Department of Planning, Industry and Environment
 Social and Infrastructure Assessments
 (Planning and Assessment)

**Re: State Significant Development - SSD 10391 – New Liverpool Primary School
 (18 Forbes Street, Liverpool NSW 2170)**

Thank you for your correspondence dated 25 June 2021 requesting Liverpool City Council's comment on the State Significant Development for the construction of a new Liverpool Primary School at 18 Forbes Street, Liverpool.

ELEVATION WEST

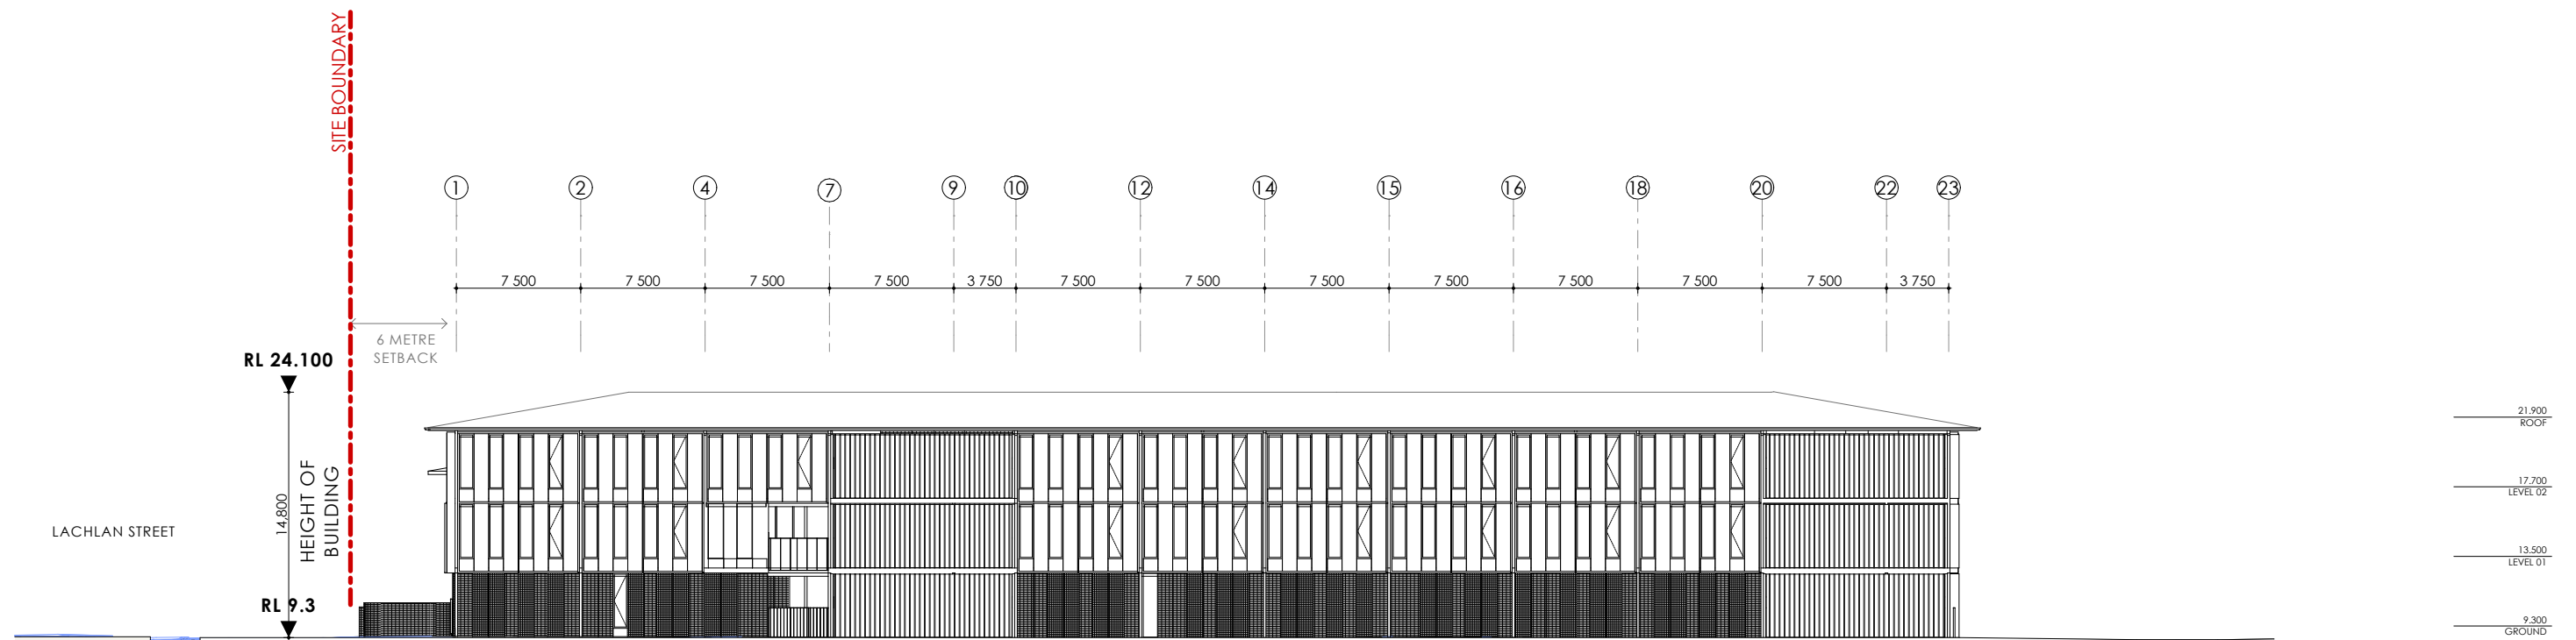
The roof form identified is quite basic. Whilst cost effectiveness is a key consideration, extending larger eaves overhangs along the western, northern, and eastern sides of all buildings can serve to reduce the ongoing operational costs, particularly in summer months where Liverpool suffers from urban heat island effects.

Figure 1.34: Moderate Scenario Cycling Infrastructure

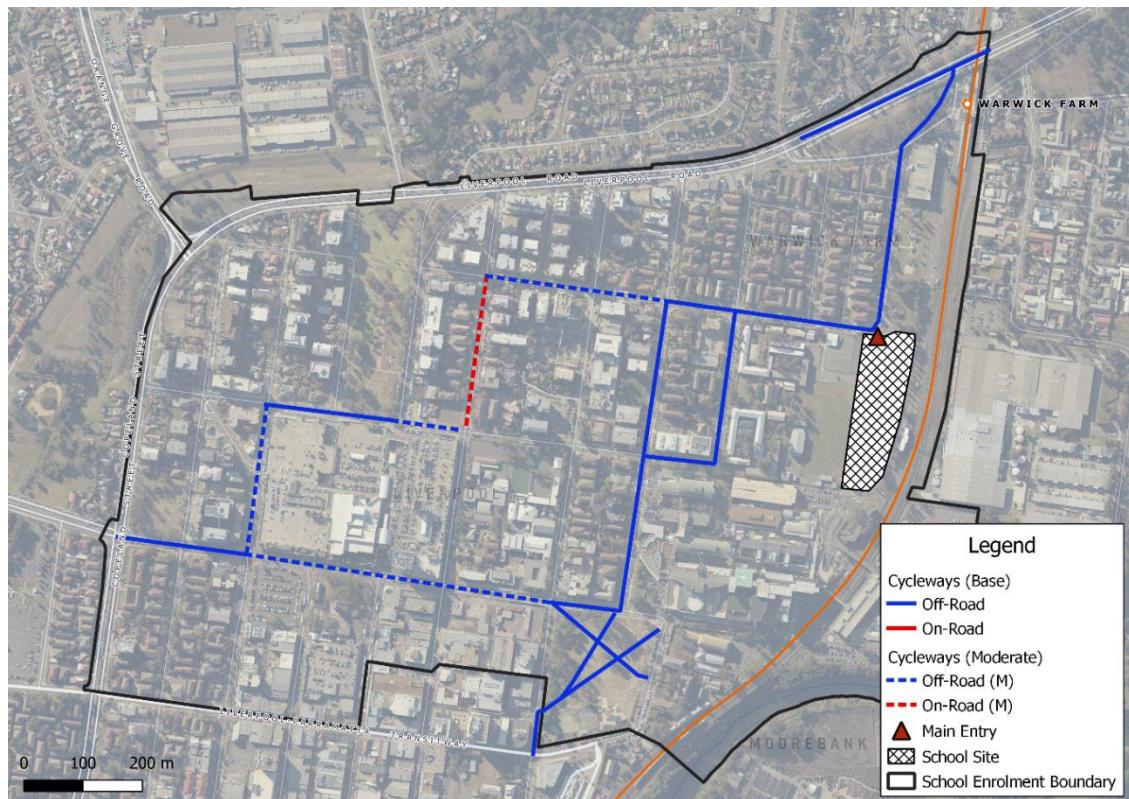
- b) The existing facilities are fragmented and do not sufficiently provide key trunks of safe cycling infrastructure, appropriate for all ages. It includes the recommended cycling infrastructure, in alignment with the Liverpool City Council Bike Plan. It recommends that SINSW investigate the required works in collaboration with Liverpool City Council.

- c) It notes that while the recommendation of George Street as an on-road cycling facility is to ensure congruence with Liverpool Council's Bike Plan, consideration should be given to its delivery as an off-road facility, providing additional safety and comfort for the New Liverpool Primary School students that may ride to school.
